About the application

Application number: 2019/93605	
What is the application for?:	Erection of 1 dwelling
Address of the site or building:	April Court, Roberttown, Liversedge, WF15 7RB
Postcode:

SITE PLAN 1:250

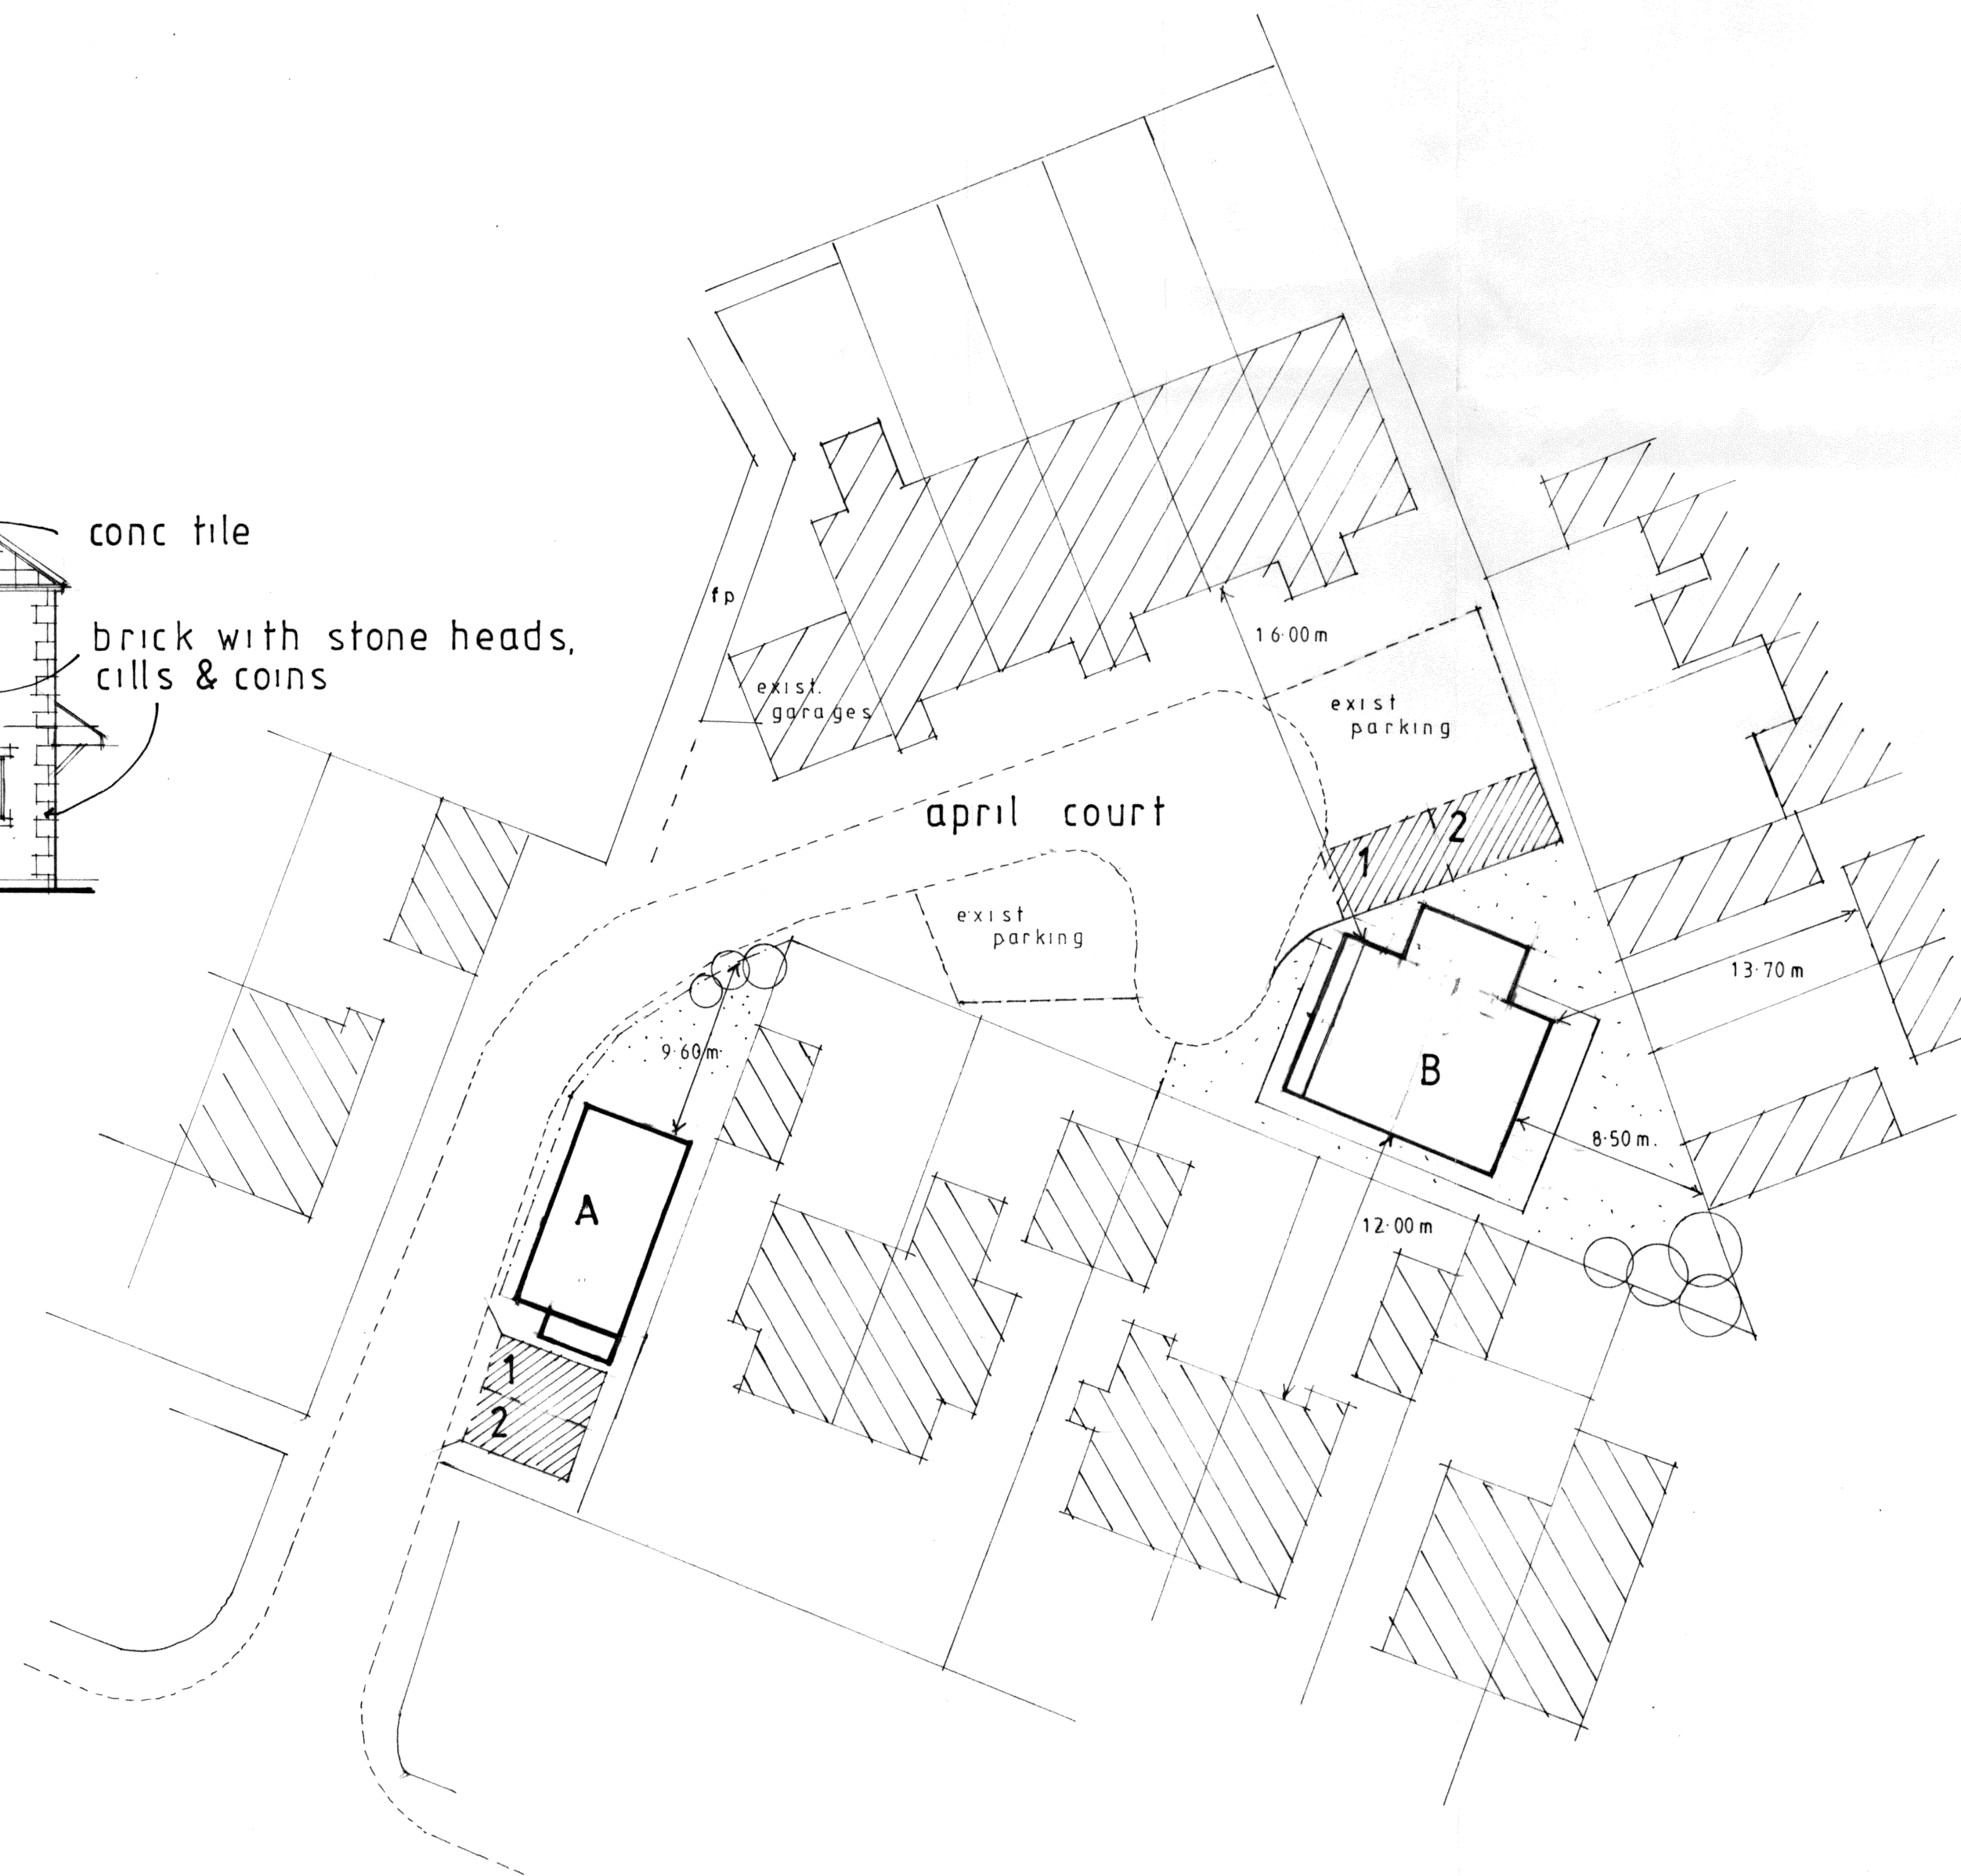
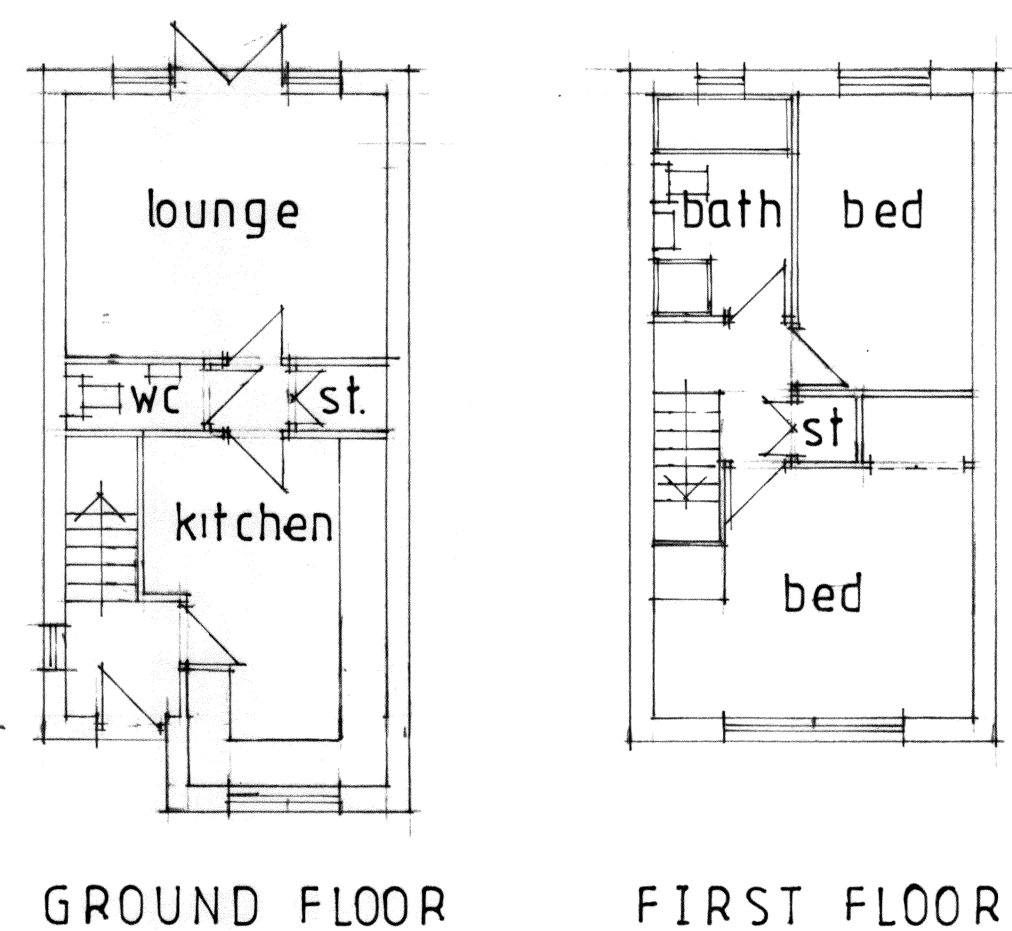
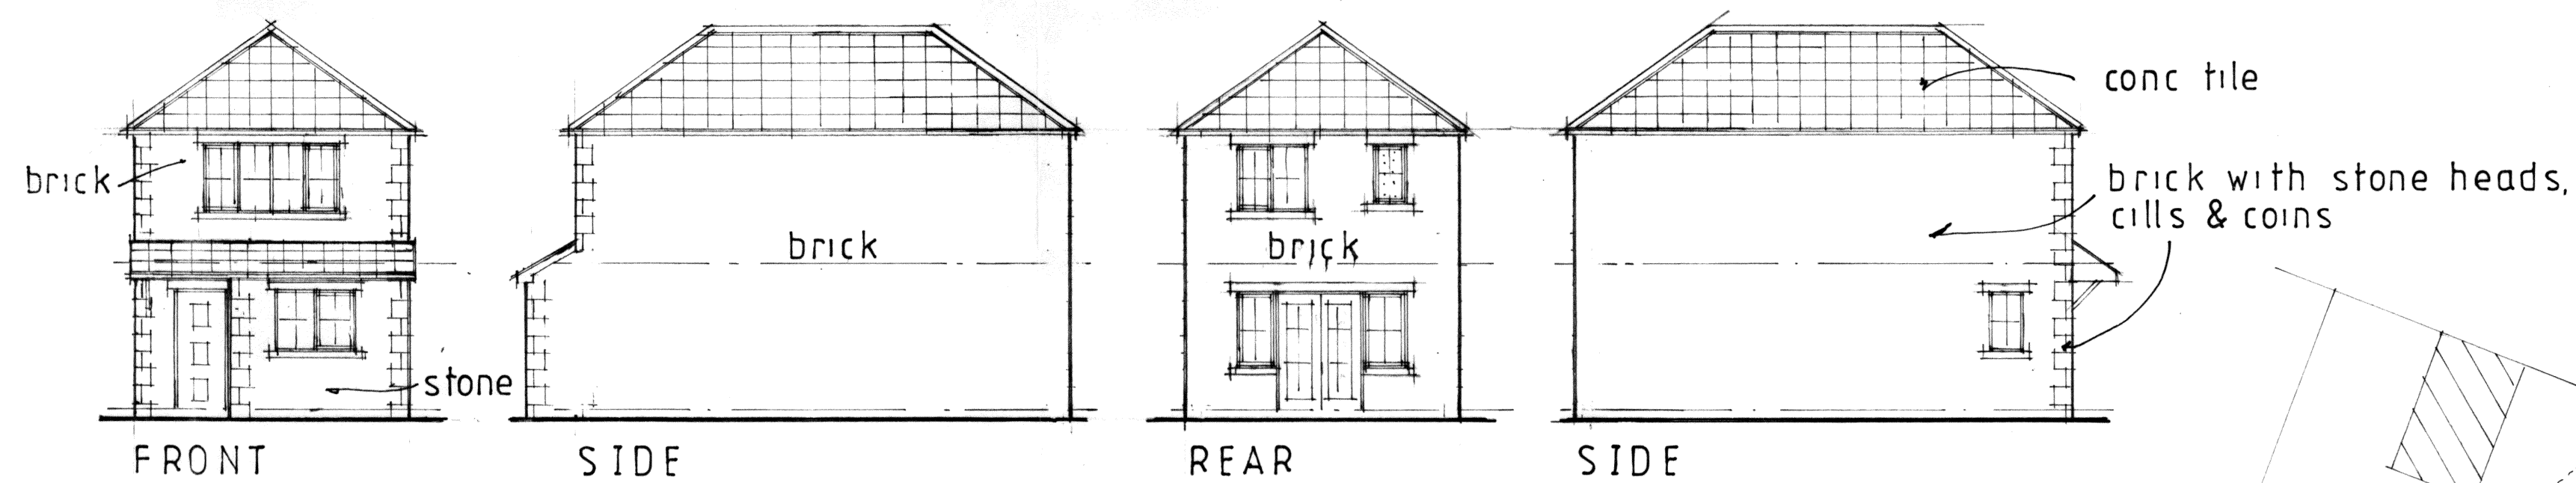
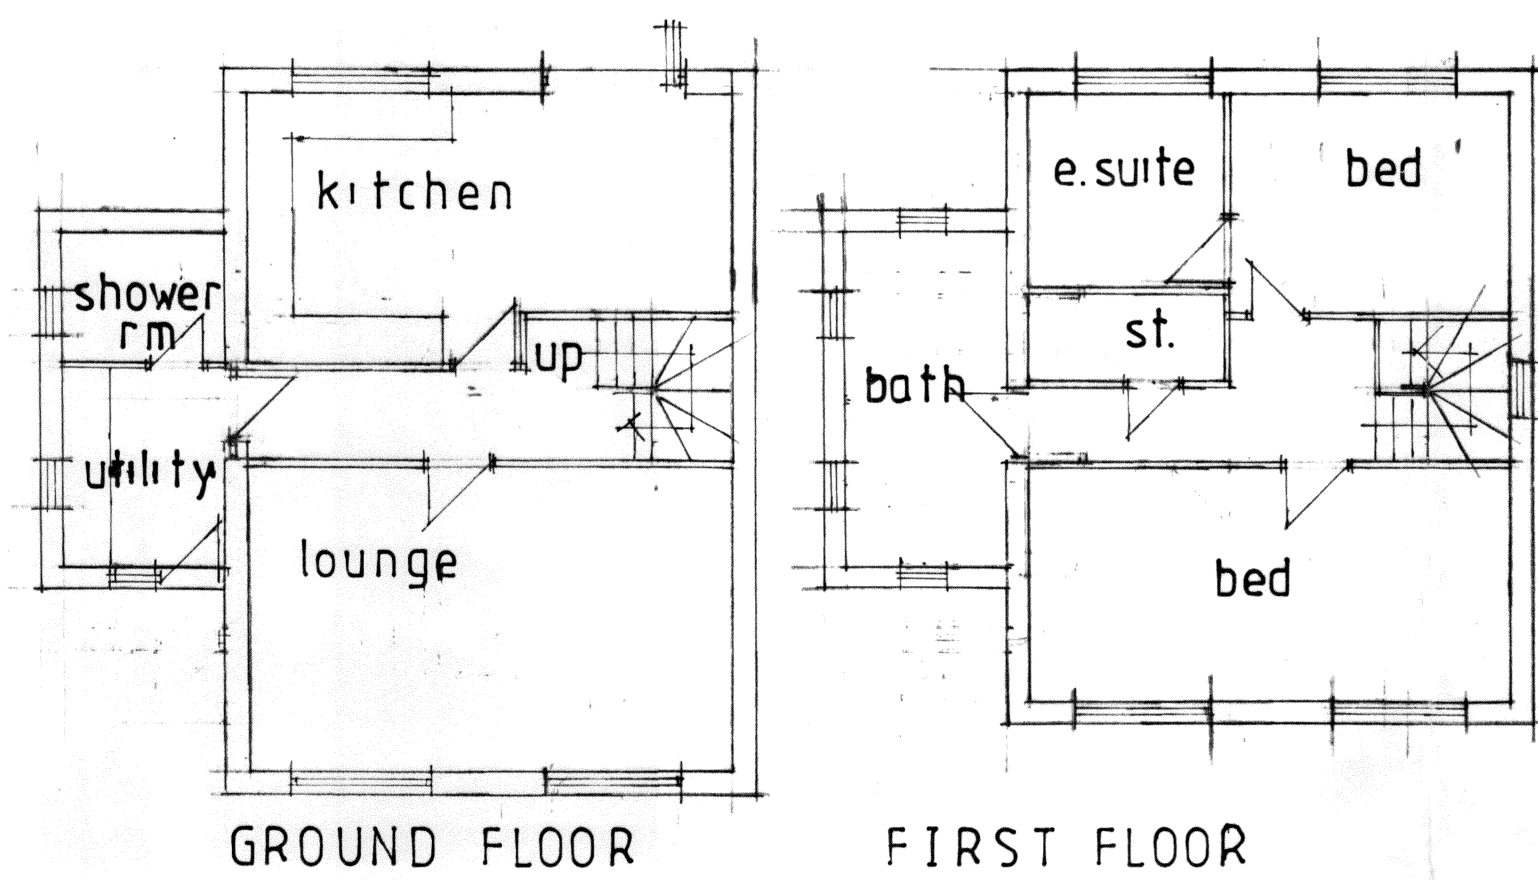
Type of comment: An objection
This land was to be a green area for residents of the Cort consequently the trees . Should the change of use be allowed I would reject the application as either side or back would look into home losing privacy . would question a fire risk as insufficient space for hydrant and other emergency services
